July 1, 2005

RE: Vista View Estates Plat (P-05-03) - SEPA Comments and Plat Comments

Mike Smith, Senior Planner

VISTA VIEW ESTATES
PTN. SE 1/4, SEC. 1, T.17N., R.18E., W.M.
KITITTAS COUNTY, STATE OF WASHINGTON
DWN BY S.K./G.W. DATE 02/05 JOB NO. 04663
CHKD BY D.NELSON SCALE 1"=150' SHEET 1 of 3

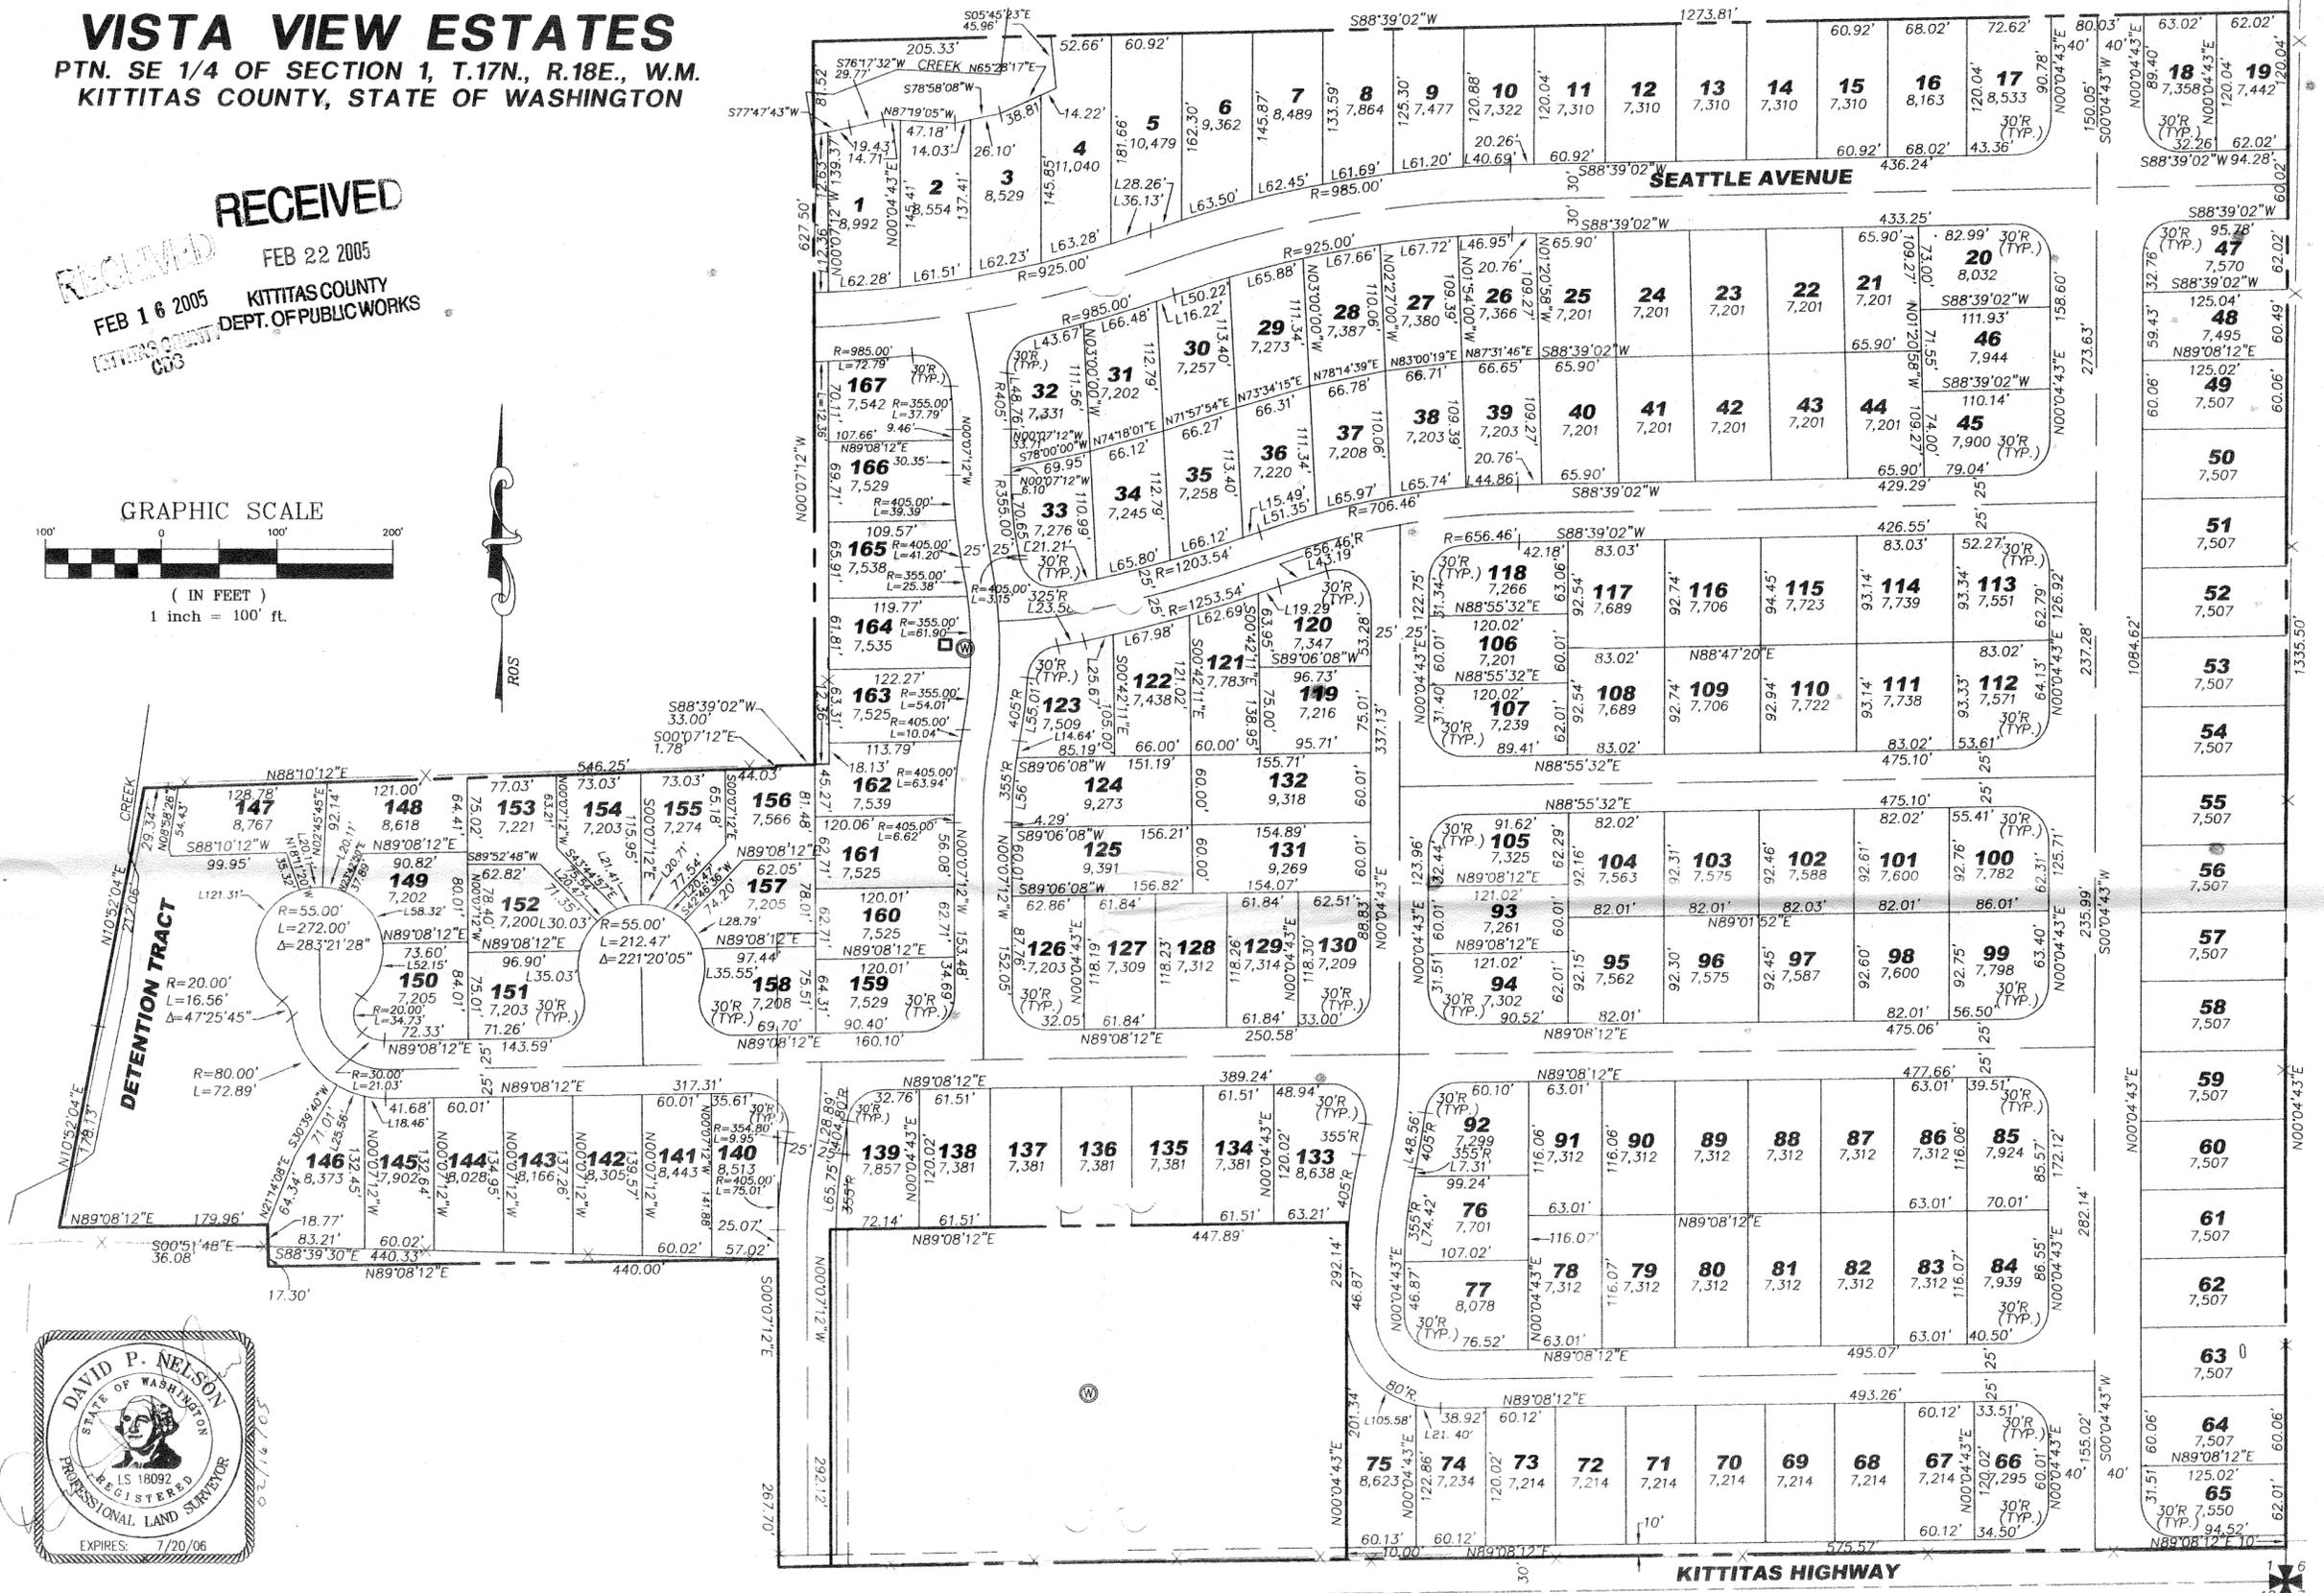
The Vista View Estates plat as proposed does not provide any north/south extension from Kittitas Highway and instead keeps all traffic entering from Kittitas Highway internal to the development except for a future option to extend Seattle Avenue to the west to connect with Willow Street. A more coordinated grid street system in this plat must provide for the future arterial/collector street extension northward to Pfenning Road, either along that eastern property line as the City's Comp Plan has identified, or at some other logical location, such as perhaps Oak Street. In addition, the Seattle Avenue corridor must be extended to connect with that north/south arterial/collector to provide neighborhood connectivity. The City respectfully requests that as a SEPA condition, the applicant be required to work with the City to identify, plan and provide for a future north/south arterial/collector route between the Kittitas Highway and Pfenning Road and to extend Seattle Avenue through the plat to connect with that north/south arterial/collector.

The City incorporates the SEPA comments above as also being comments on the plat application itself and requests that they be made conditions of preliminary plat approval. The Vista View Estates Plat will have to be serviced by City utilities. The cost of extension of all required utilities and other construction improvements will have to be borne by the proponent. The subdivision must be constructed according to applicable design plans approved by Kittitas County and/or the City of Ellensburg, for all water, sanitary sewer, storm drainage, frontage and internal road improvements prior to final approval of the plat. A north/south arterial/collector roadway must be planned and provided for between the Kittitas Highway and the north property line. And all Kittitas County Critical Areas Ordinance requirements must be complied with.
